**Re: Car Crafters Automotive Repair Garage Grading and Drainage Plan,
Engineer's Stamp dated 10-21-11 (F15/D036), 5404 Edith Blvd. NE**

Based upon the information provided in your submittal received 11-16-11, the above referenced plan cannot be approved for Building Permit until the following comments are addressed:

Project Number
Drawn By T.D.S.
Checked E.J.L.
Issue Date 12/22/2011
GRADING AND DRAINAGE PLAN

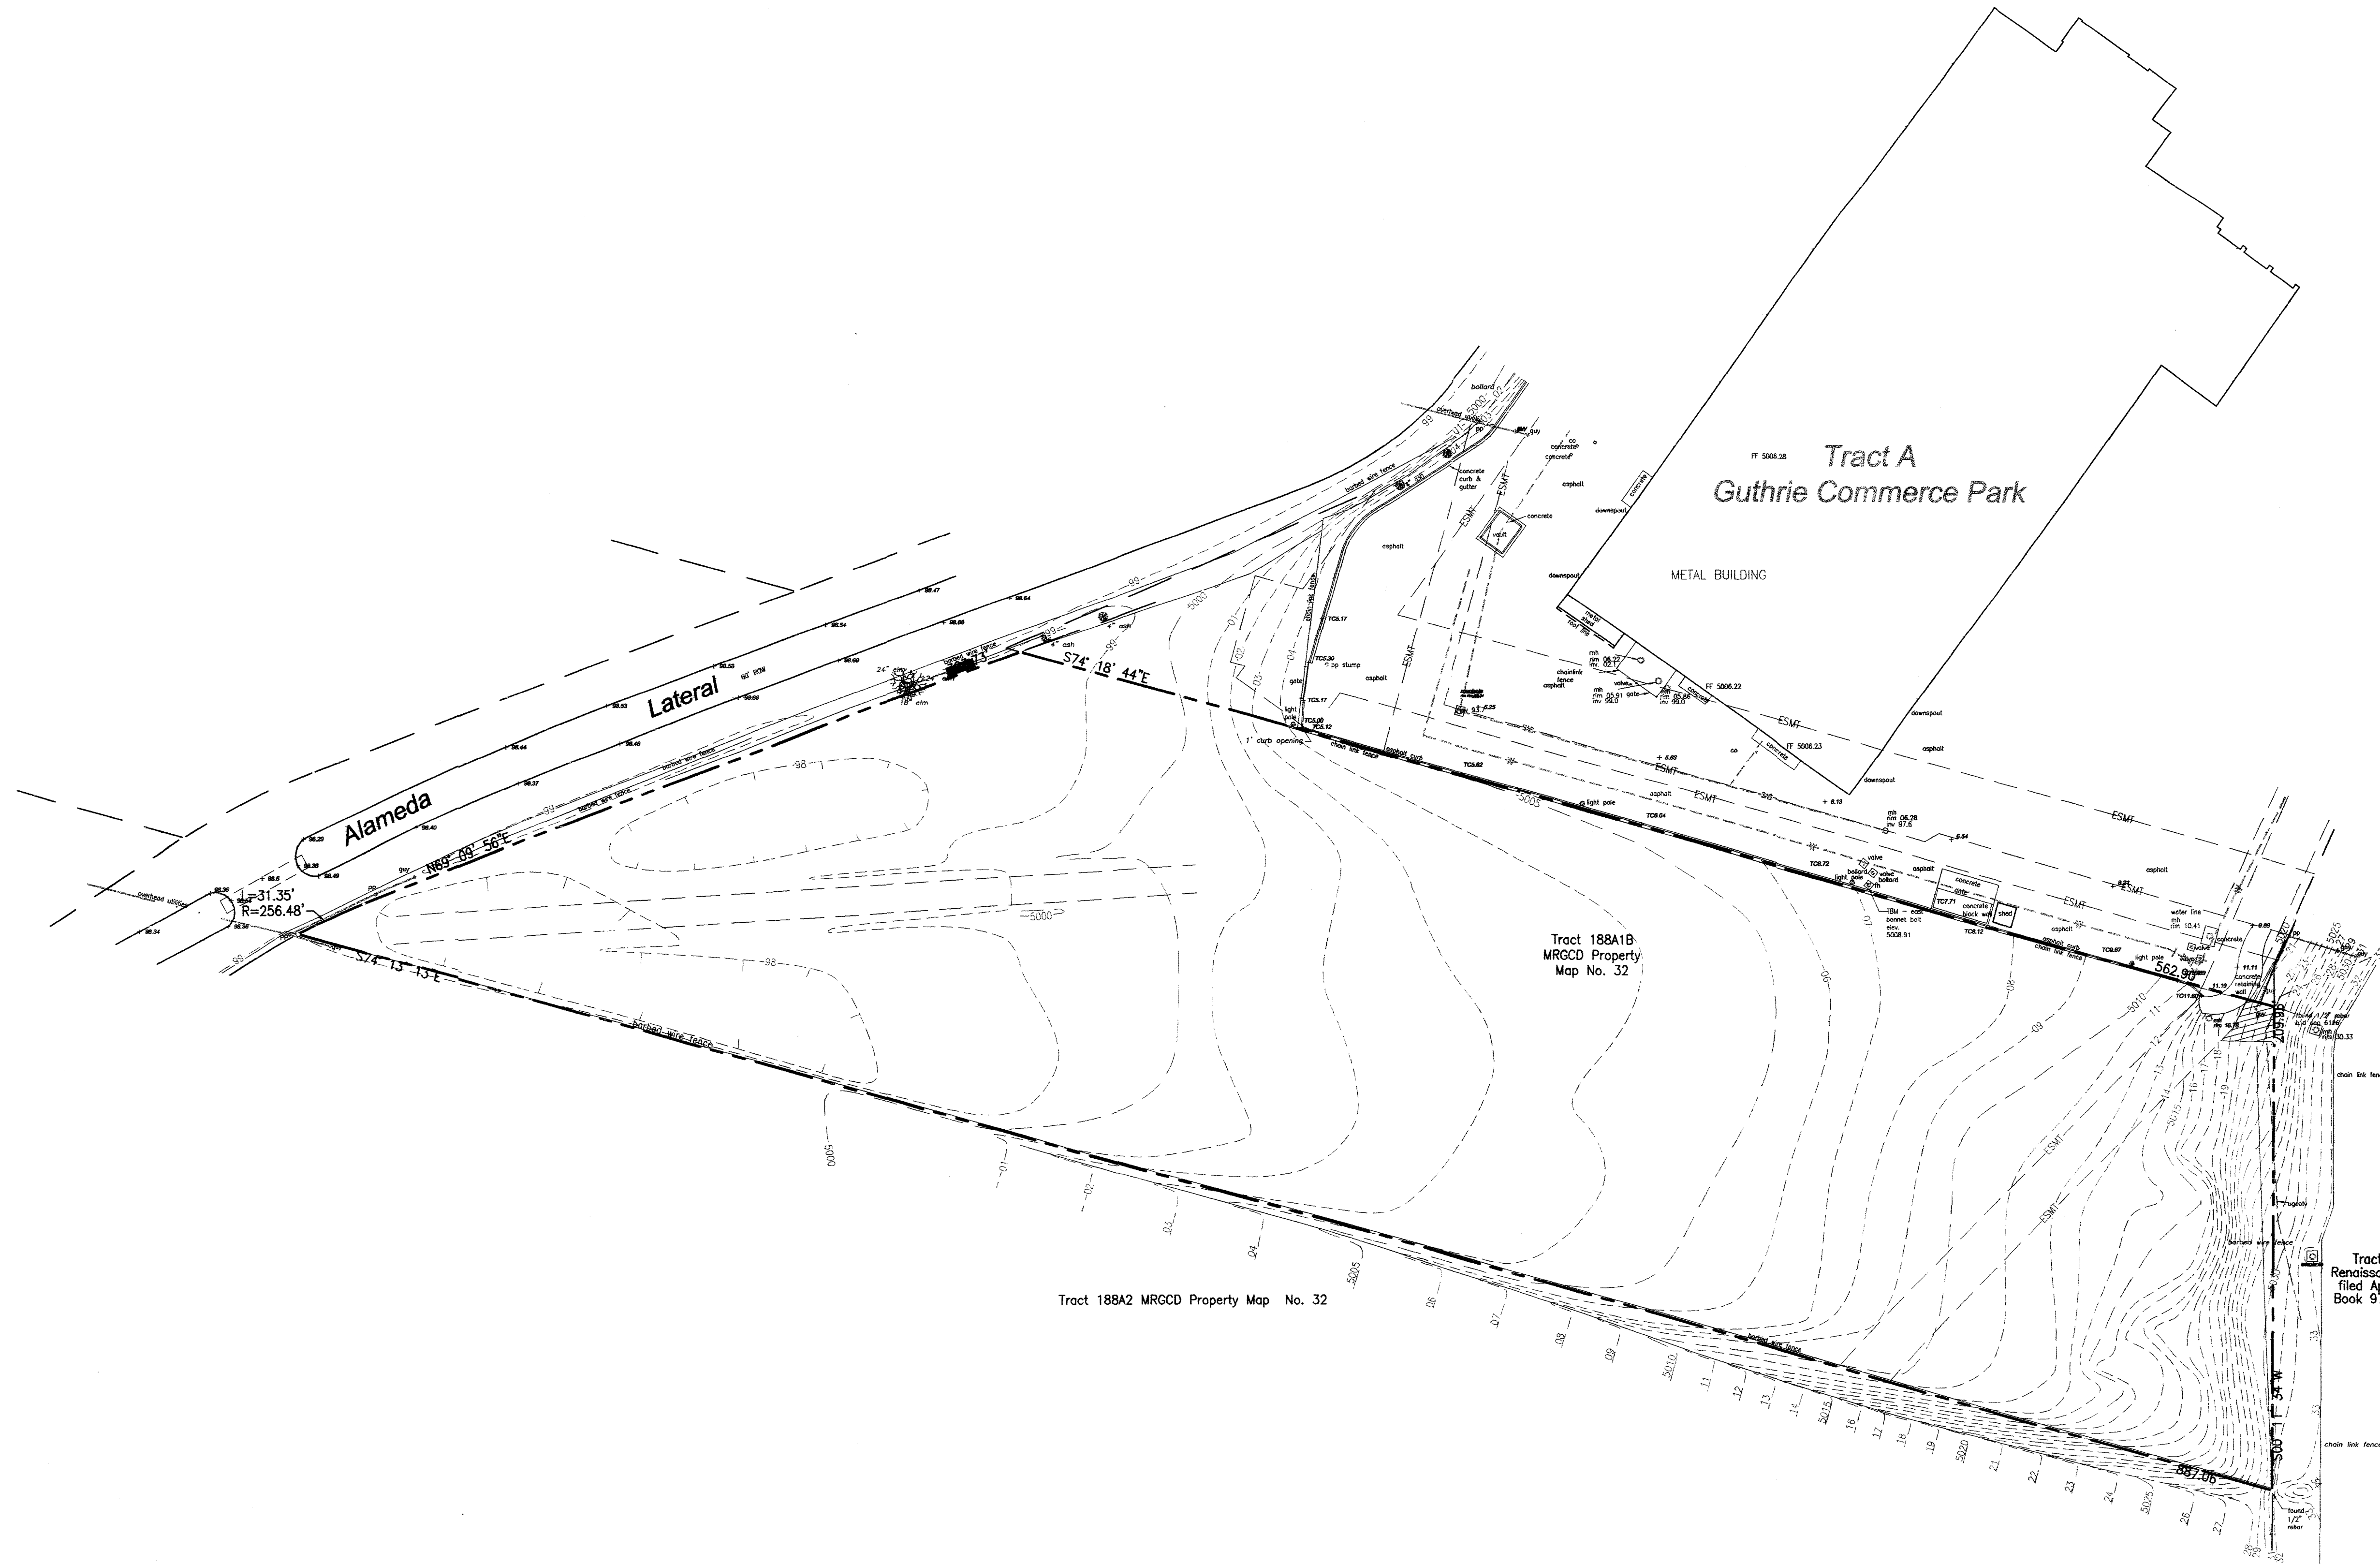
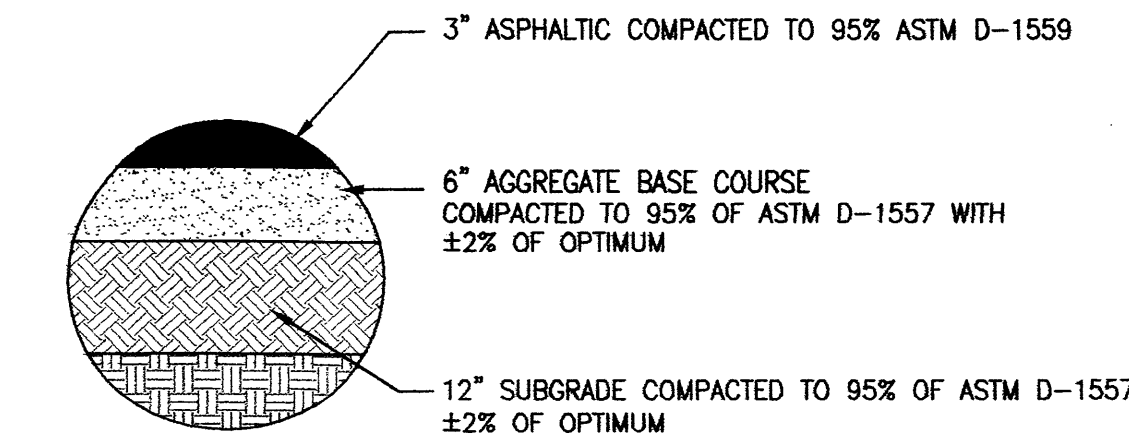
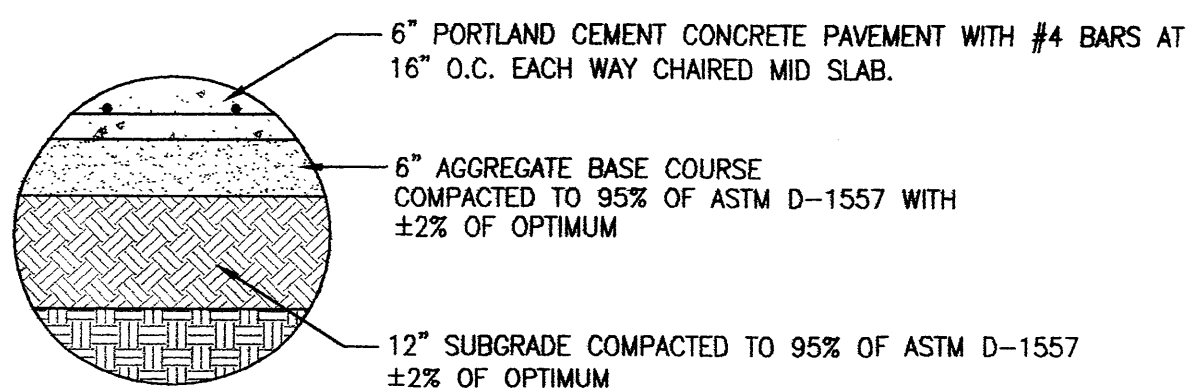
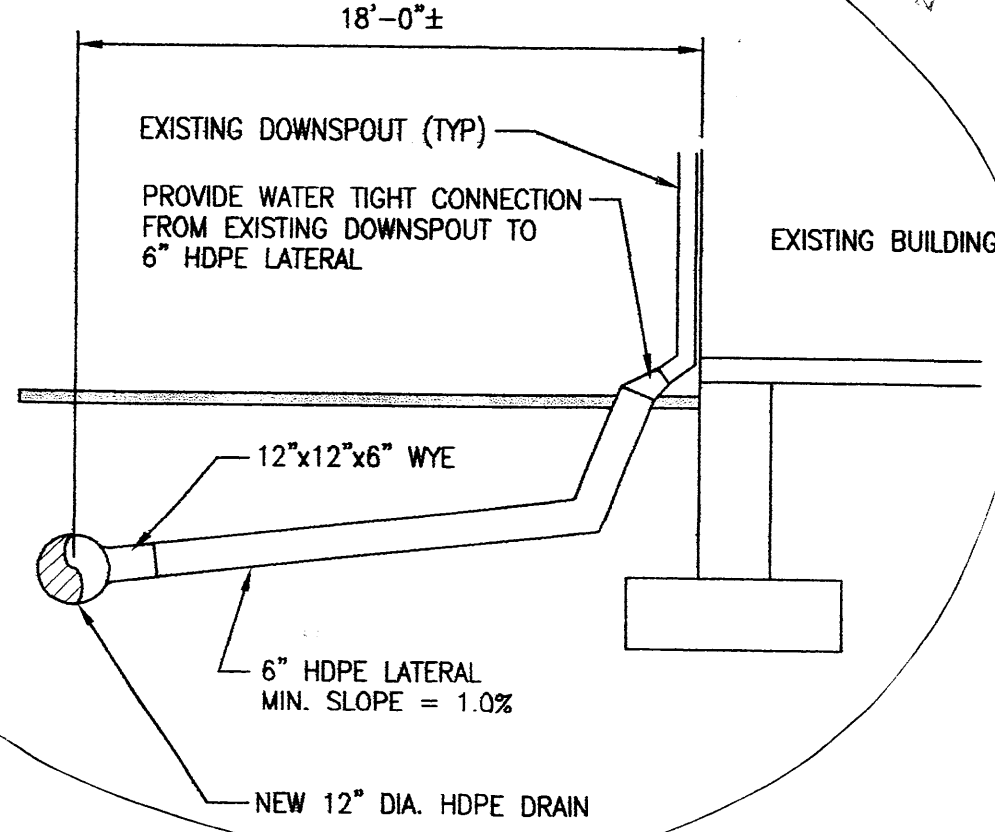
- Provide City BM.
- Include all the runoff calculations.
- Provide required ponding volume calculations.
- Add the 100-Yr WSEL to the plan. Include the proposed retention pond volume calculations. Provide emergency overflow with calculations.
- Will there be a concrete rundown for the pond to avoid erosion?
- Please route the runoff from Basin B to the proposed retention pond.
- The area east of Basin B appears to drain south. Please make sure that this area will be included as part of the retention pond volume.
